Ref: 2021/62/94184/W

Thank you for your letter dated 5th November 2021 relating to the above referenced planning application at 1 Summerfield Grove.

Proposed South Elevation 1:100

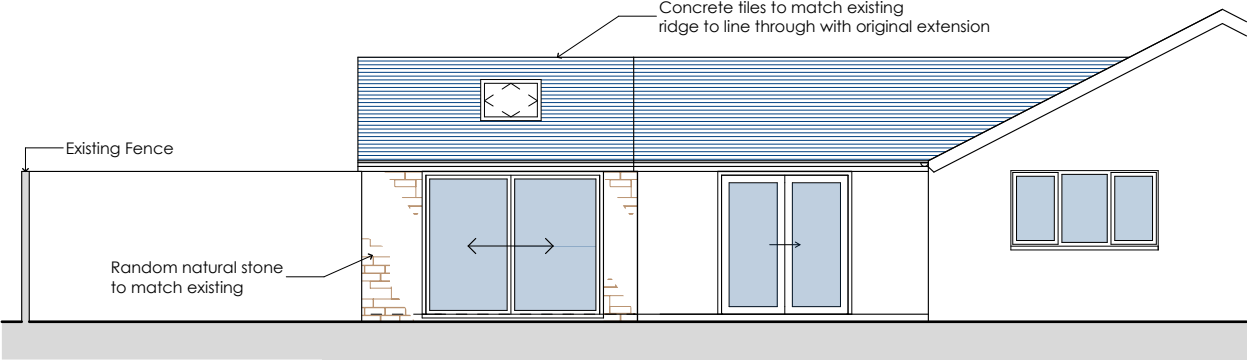
The latest extension of 1 Summerfield Grove moves the boundary of the house much closer to its neighbours increasing the likelihood of noise with patio doors on the southern elevation directly overlooking the rear bedroom window of 35 Manor Park Way resulting in a loss of privacy.

Proposed North Elevation 1:100

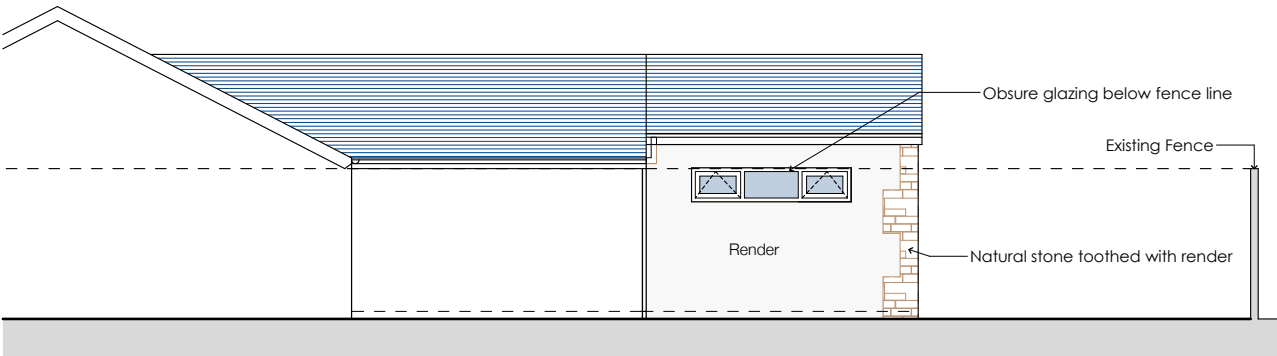
The window that has been installed in the northern elevation of the new unauthorised extension, whilst it is below the level of a current fence, is not below the level of a permanent structure, the fence being removable. This may subsequently overlook neighbours to the north, hence in the original development plans no northern facing windows were permitted.
